Environmental Assessment Report - Executive Summary

This Environmental Assessment Report (EAR) is submitted to the Minister for Planning pursuant to Section 75W of the Environmental Planning and Assessment Act 1979 (EP&A Act). Specifically this application seeks to modify Project Approval 10_0010 to account for minor external changes to the approved Dick Smith building.

Dick Smith Warehouse Facility and associated infrastructure - MP10 0010

TITLE			
SITE PLAN			
DATE	09-12-09	PROJECT No.	STATUS
SCALE	1:1000 (B1)	0931	AR/DA
DRAWN	MR	DWG No.	REV No.
CHECKED		DA01	/F
APPROVED

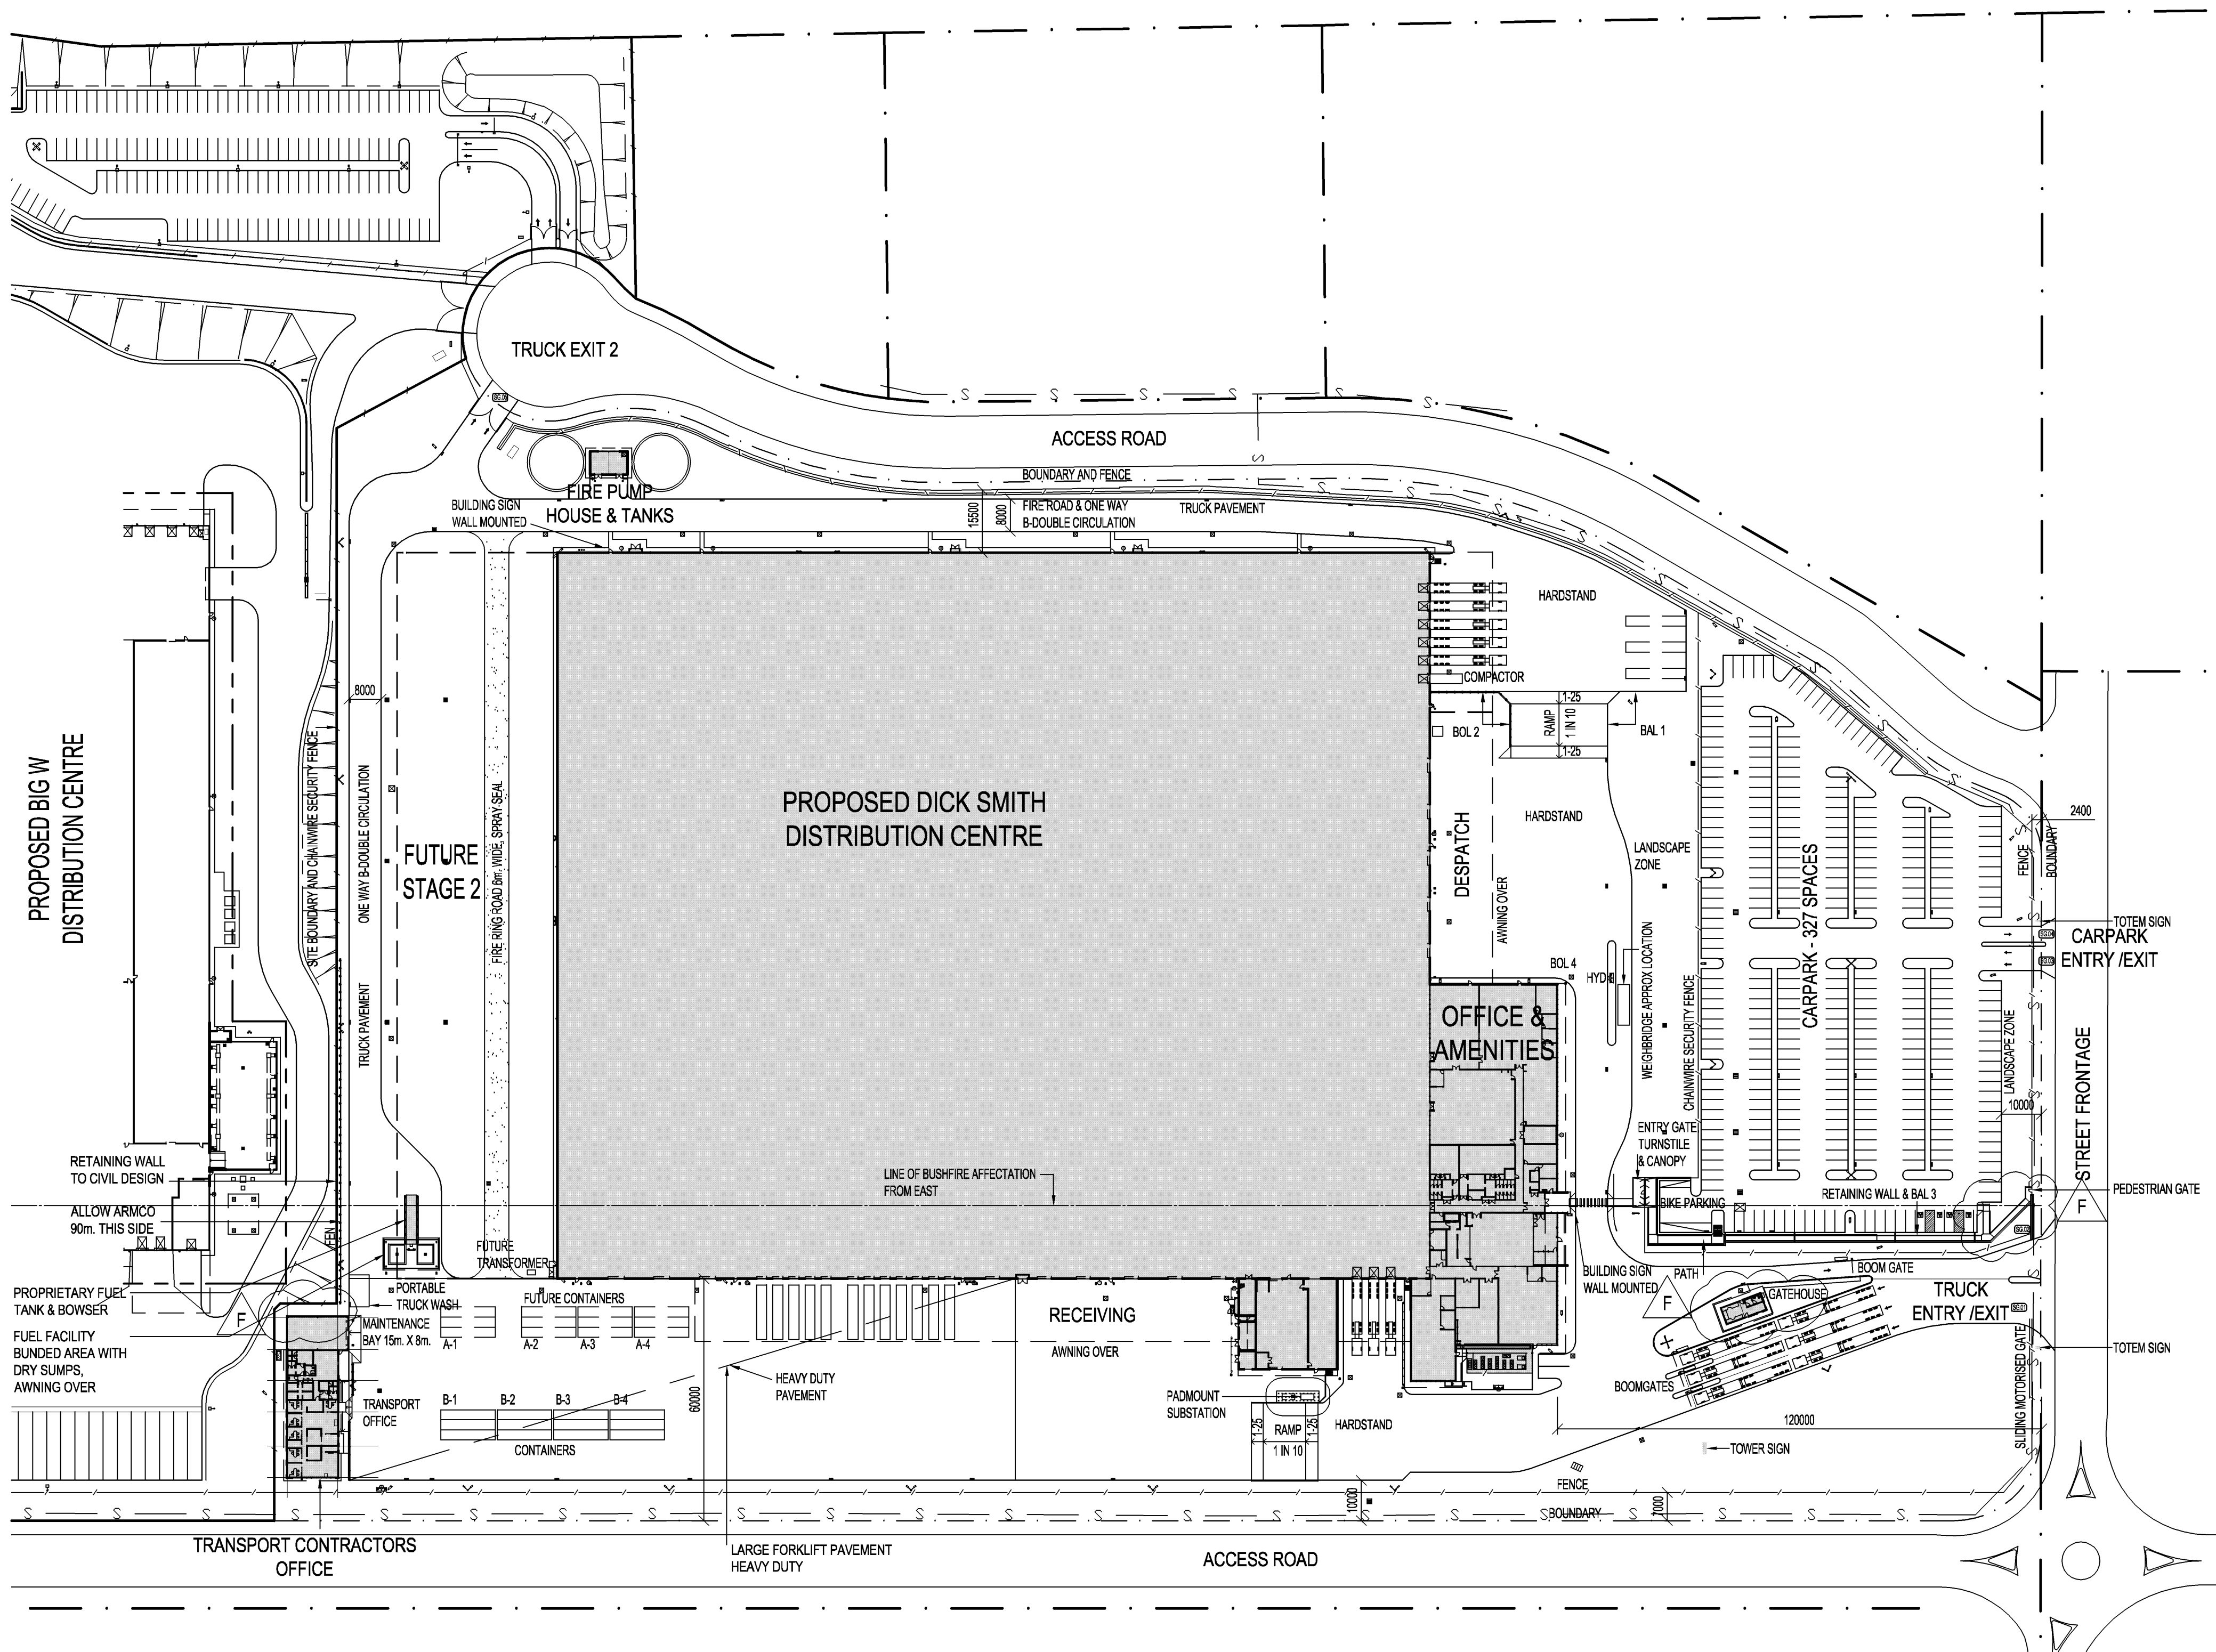
| No. | Item | Description |
|-----|-------------------------------------|---------------------------------------------------------------------------------------------------------------------------------------------------------------------------------------------------|
| 1 | Addition of a gatehouse | New item introduced for security purposes. |
| 2 | Driveway adjustment | Minor amendment to improve turning circle on exiting. |
| 3 | Boundary adjustment | Minor adjustment to meet compliance with boundary distances from structures. |
